MEMORANDUM

DATE: NOVEMBER 7, 1997

RE: FINAL DRAINAGE REPORT FOR CORNER OF GOLF COURSE RD. AND IRVING BLVD.

RE: Master Drainage Plan and Report for Tract 3A (B12/D1A1), Submitted on October 9, 1997, Engineer's Stamp Dated 10/7/97.

GRADING PLAN

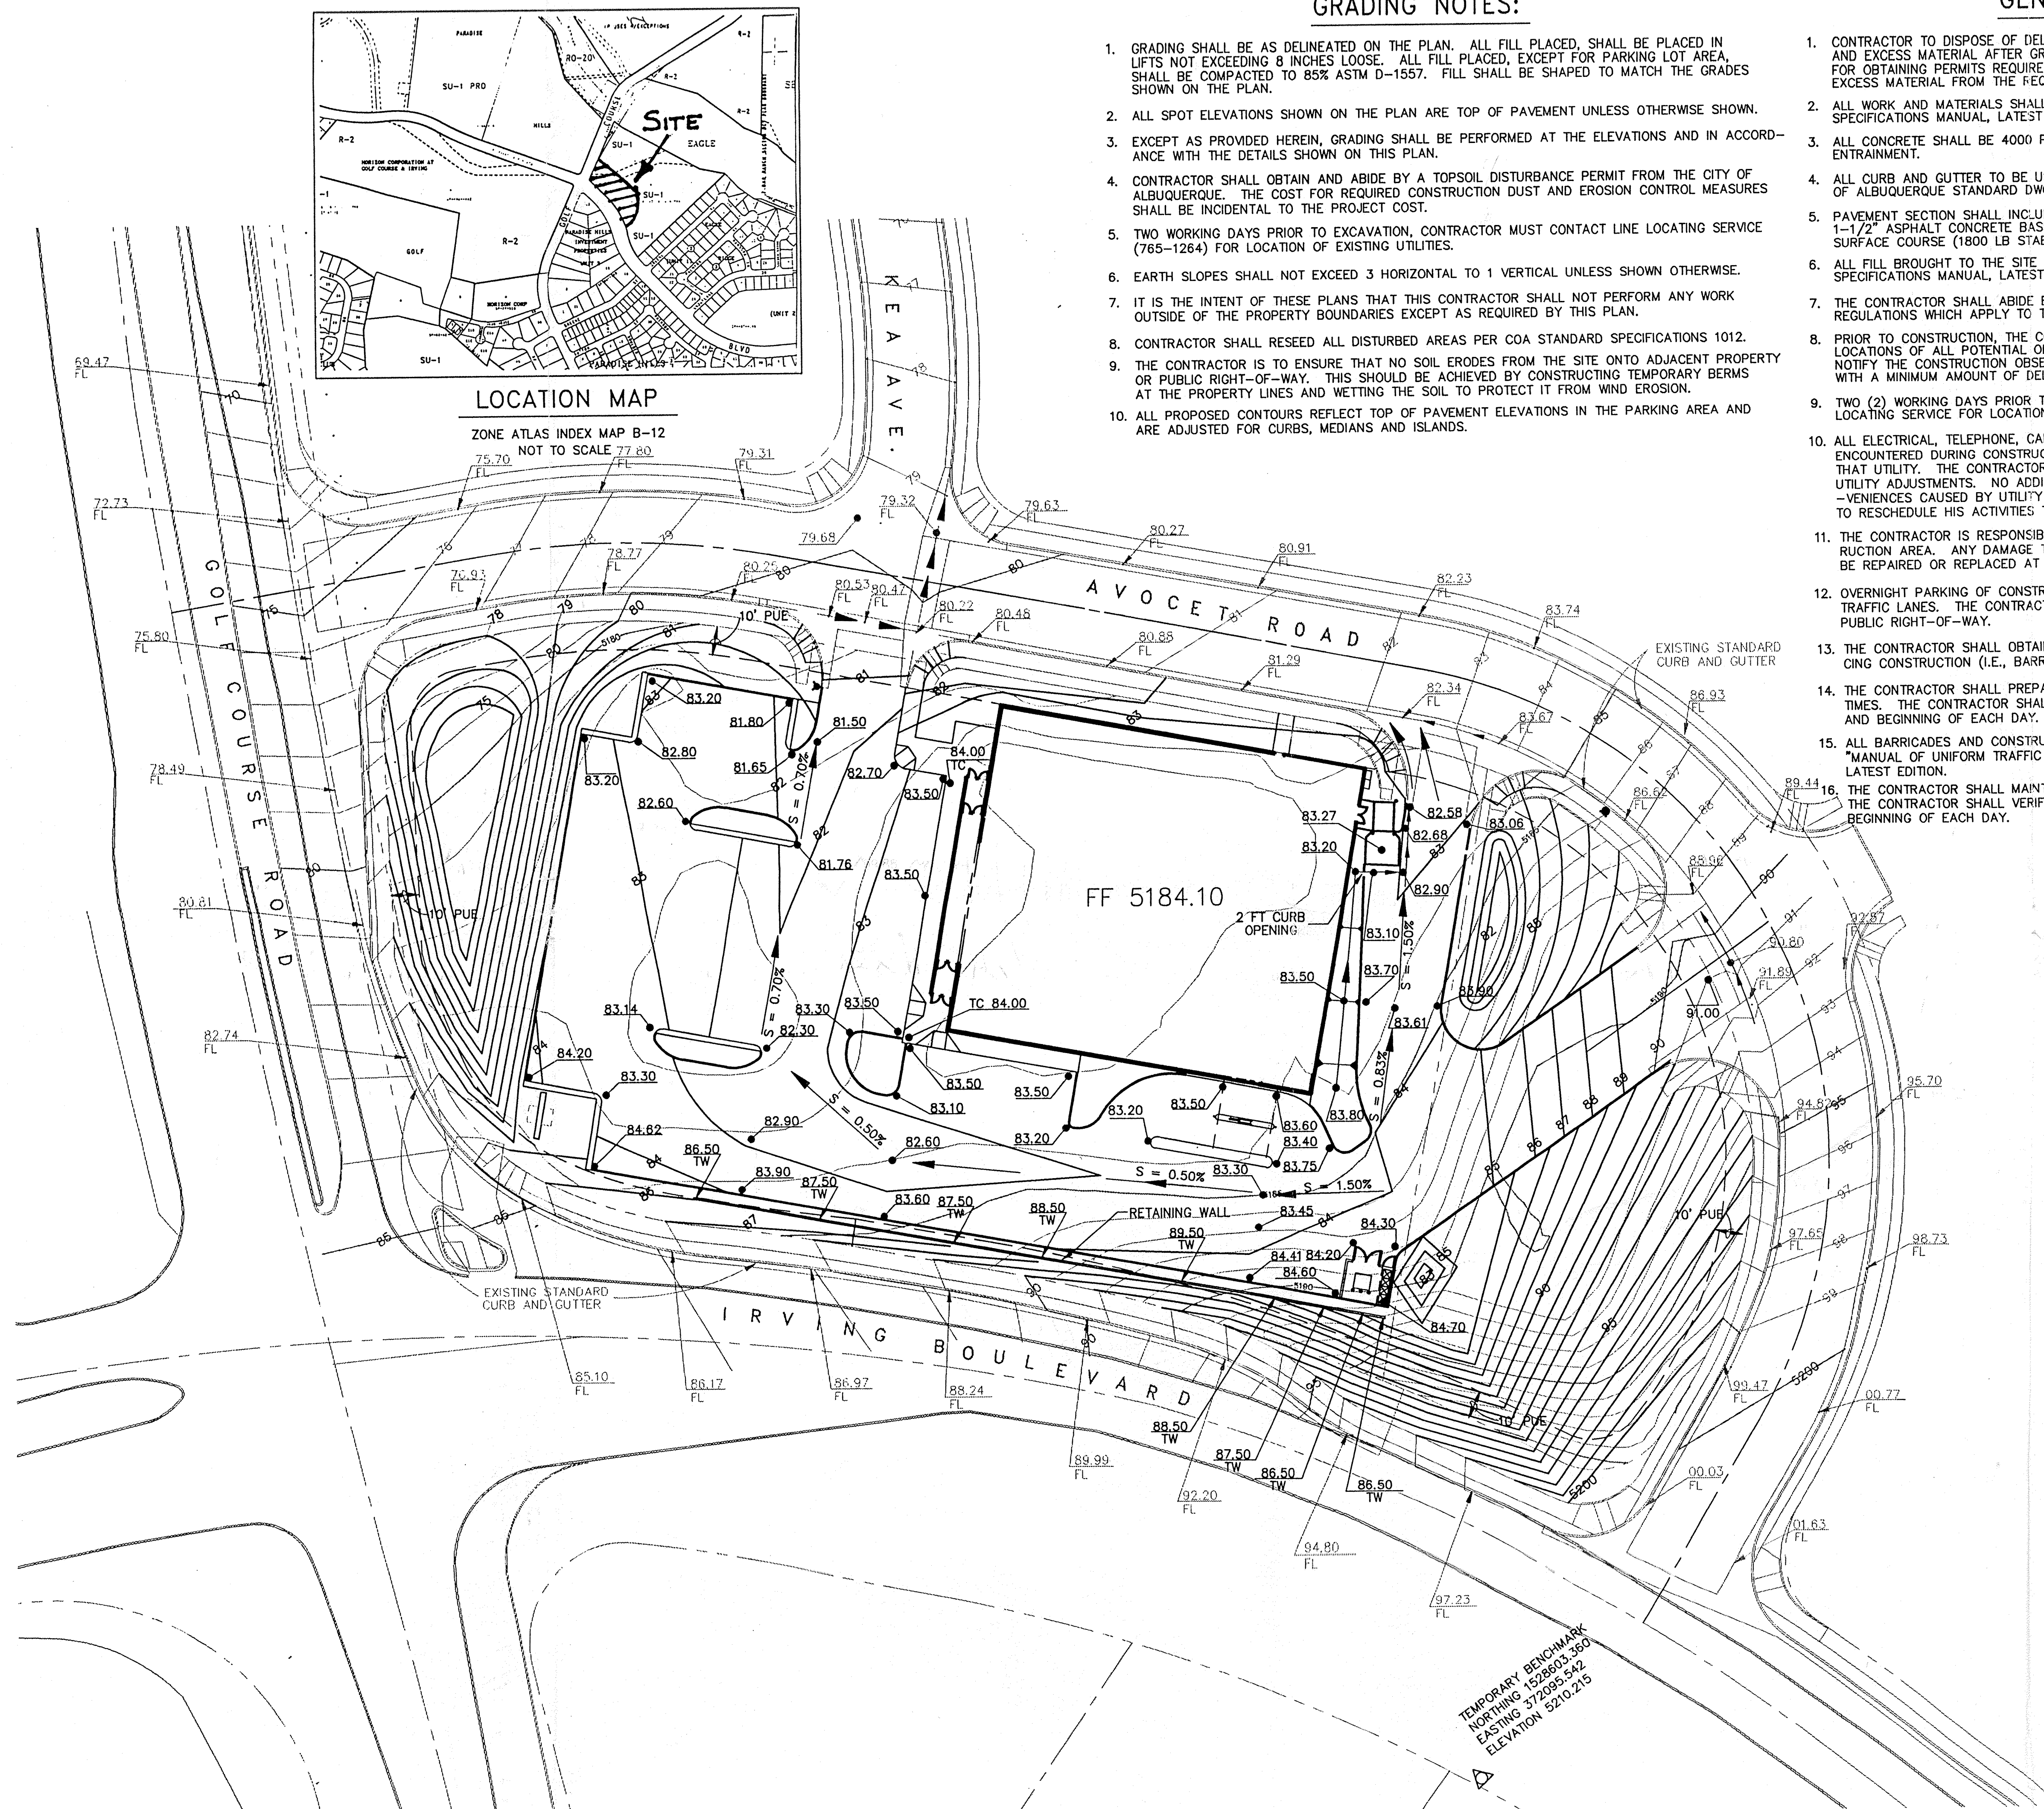
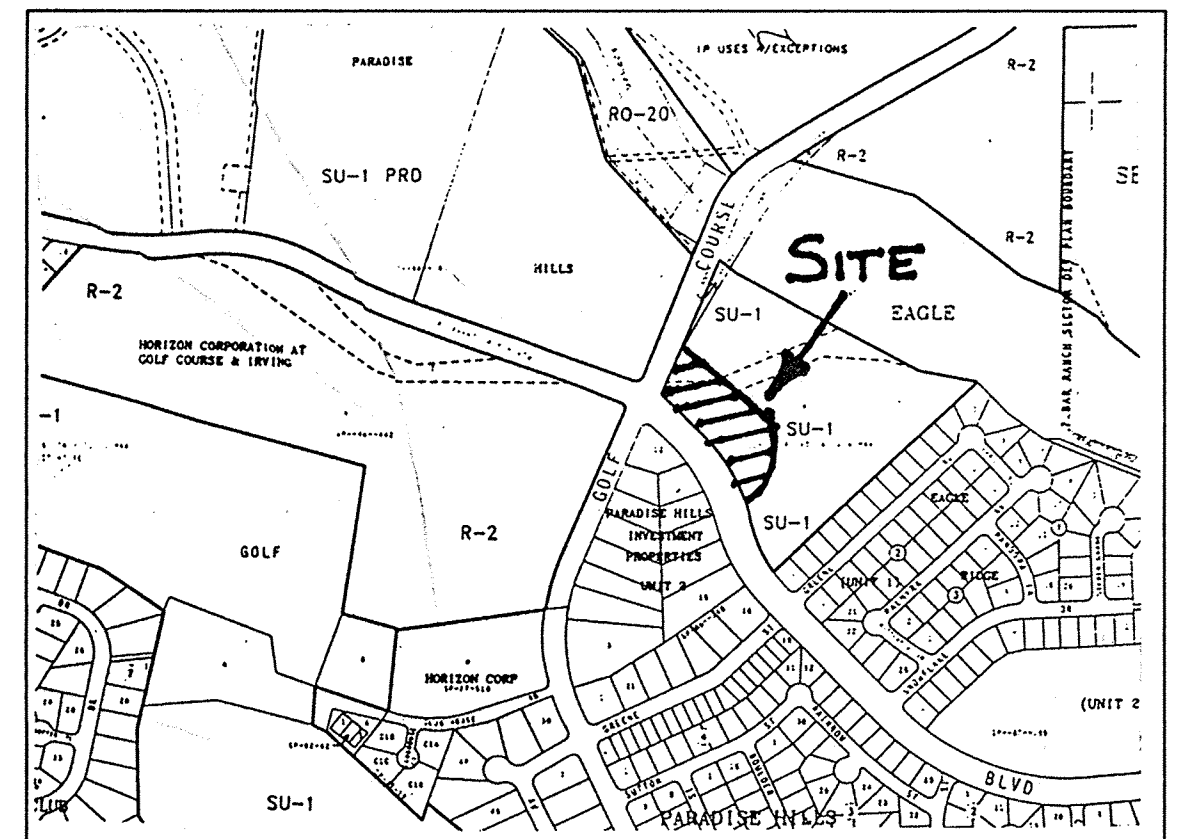
1. The Master Plan states that no flows enter the adjacent streets, however, the Osco site states that 0.9 cfs will be released onto Golf Course Road.
2. Drainage basins A1 and A2 were not labeled the same on both plans.
3. Please provide the street grades in both Golf Course and Irving. Both the existing and the ultimate street grades must be shown on the plan.

1. We have corrected the statement about flows onto Golf Course Rd. in the Drainage Report (Part I)
2. Drainage basin labels have been corrected.
3. Street grades for Golf Course and Irving are found in the information supplied by Smith Engineering for the development at the Osco Site (Basins A1, and A2).
